**United Utilities Water PLC
Developer Services & Planning**
Thirlmere House
Lingley Mere Business Park
Lingley Green Avenue
Great Sankey
Warrington WA5 3LP

Your ref: 3/2012/0834
Our ref: DC/12/4706
Date: 14-NOV-12

Location: The Former Sewerage works, Sabden, Clitheroe
Proposal: Agricultural Live Stock Building

SITE PLAN

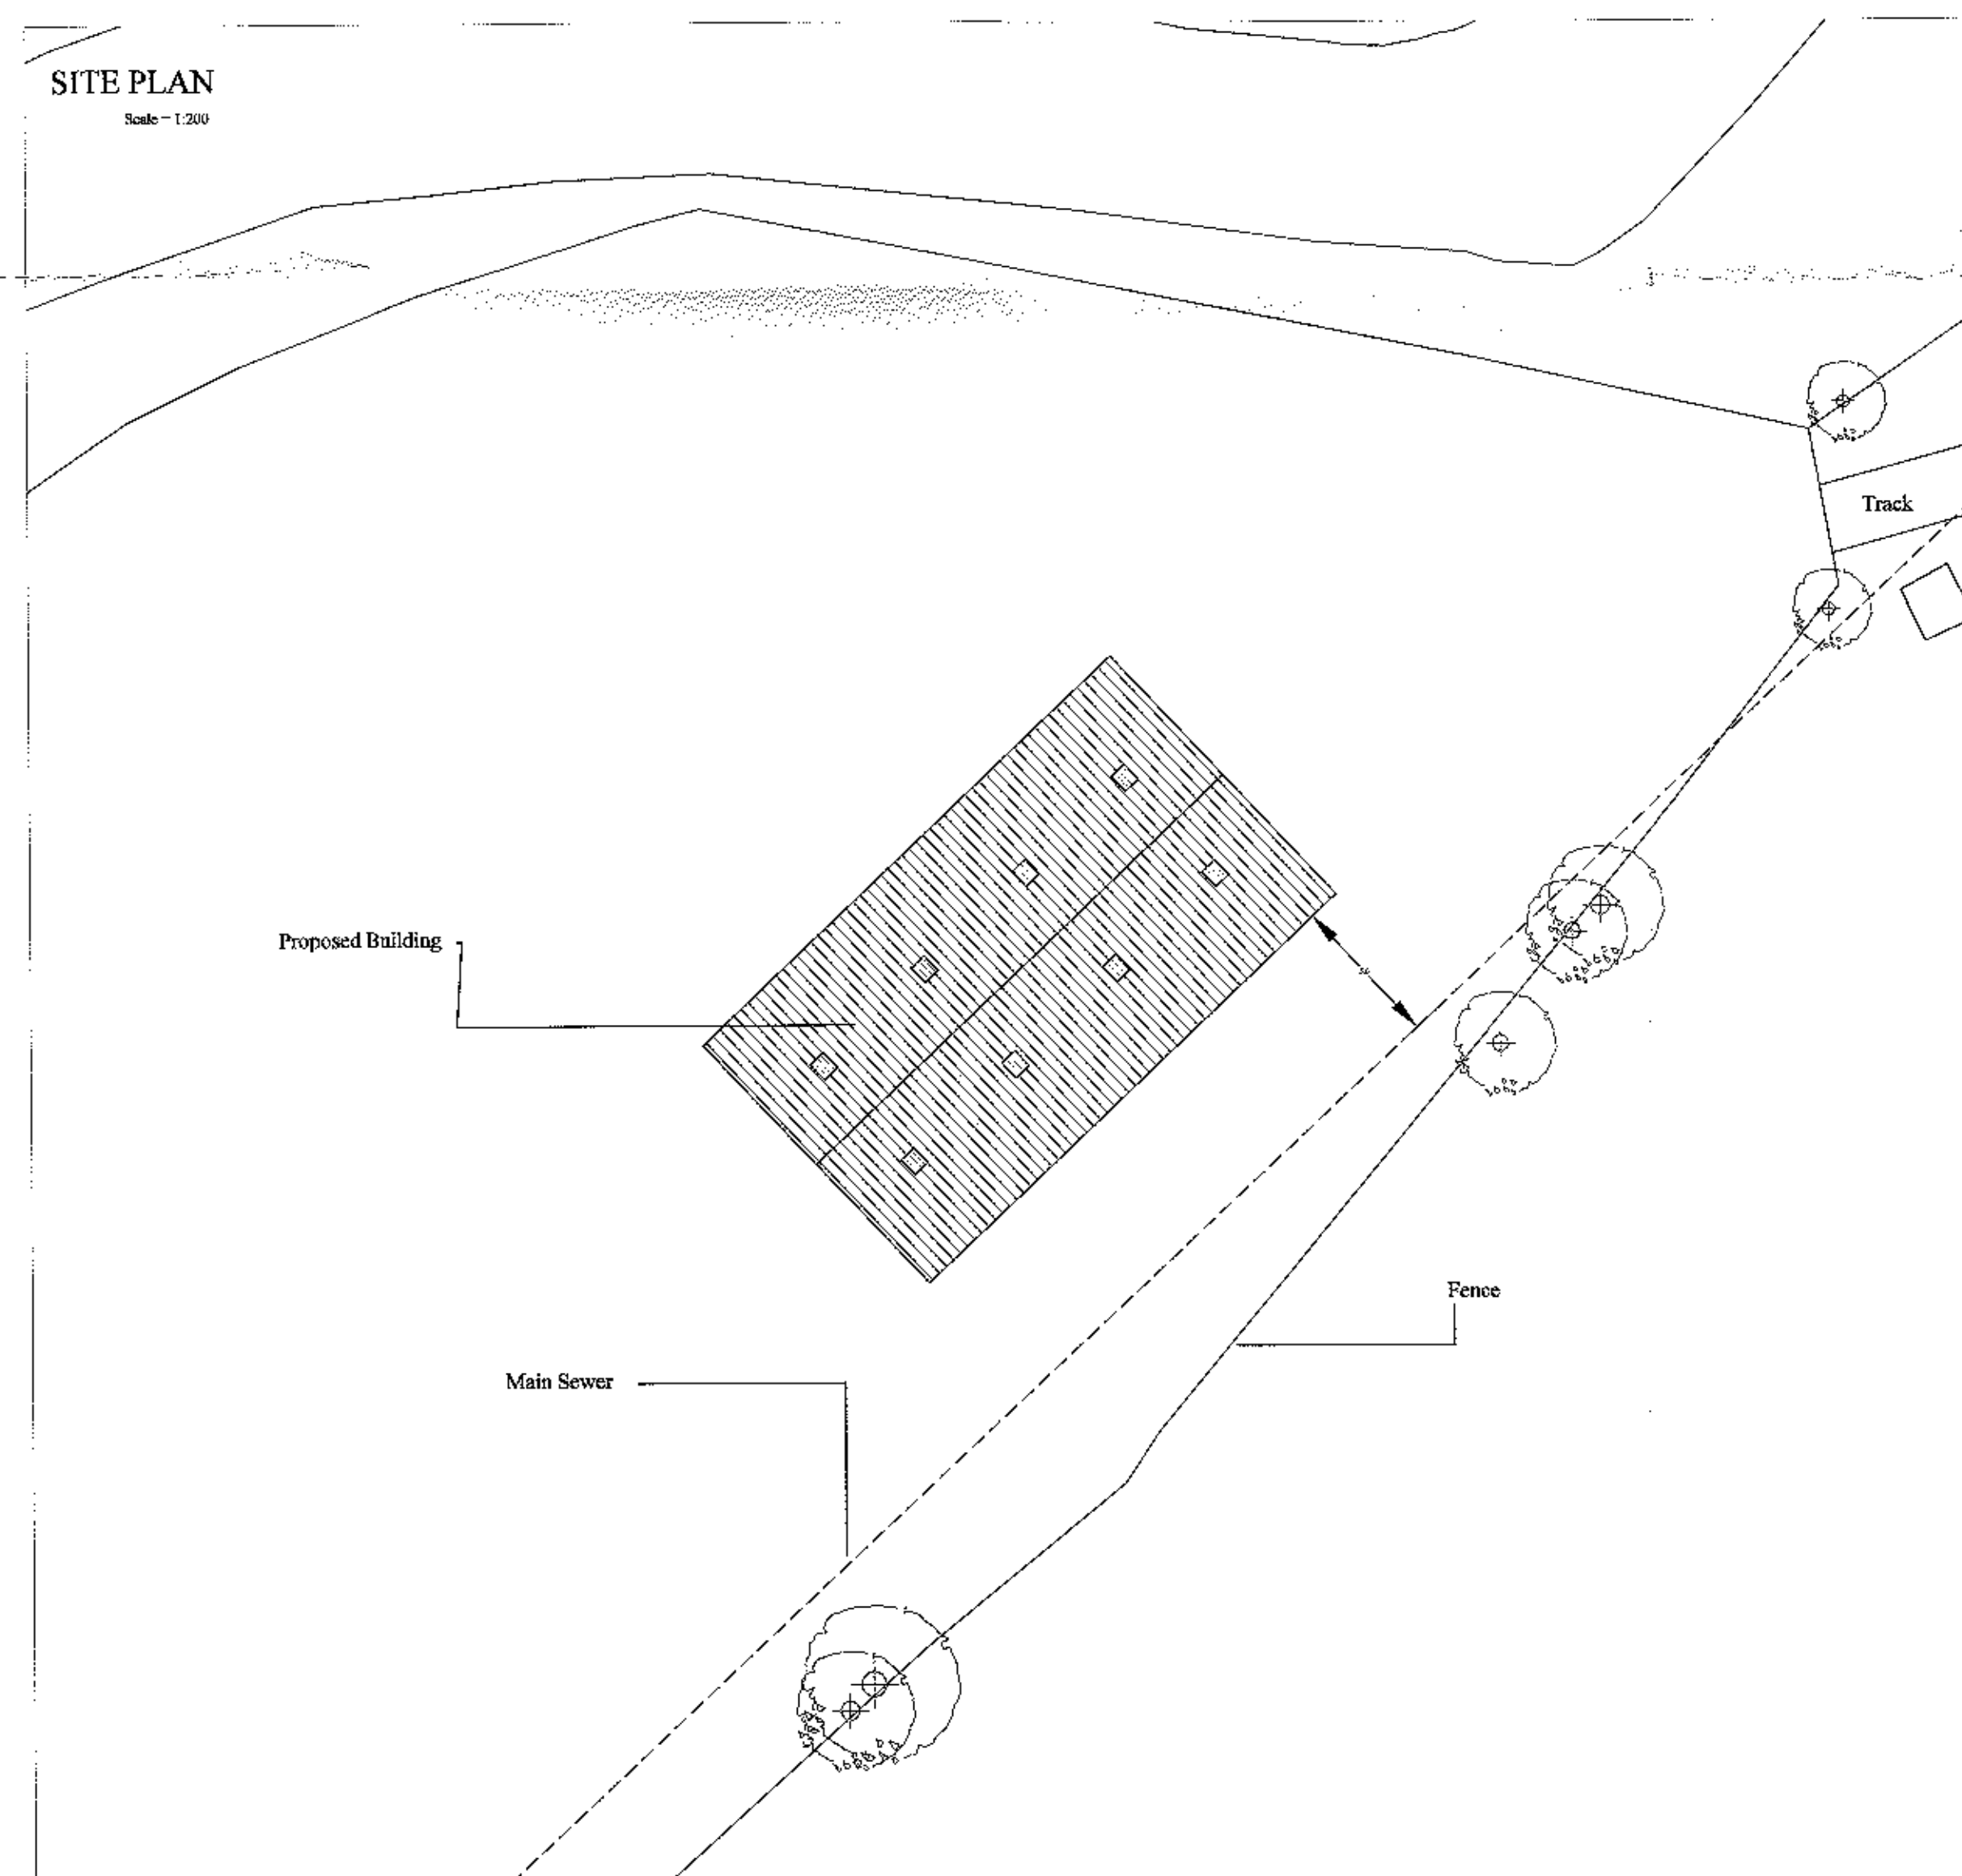
- A public sewer crosses this site and we will not permit building over it. We will require an access strip width of 6 metres, 3 metres either side of the centre line of the sewer which is in accordance with the minimum distances specified in the current issue of "Sewers for Adoption", for maintenance or replacement.
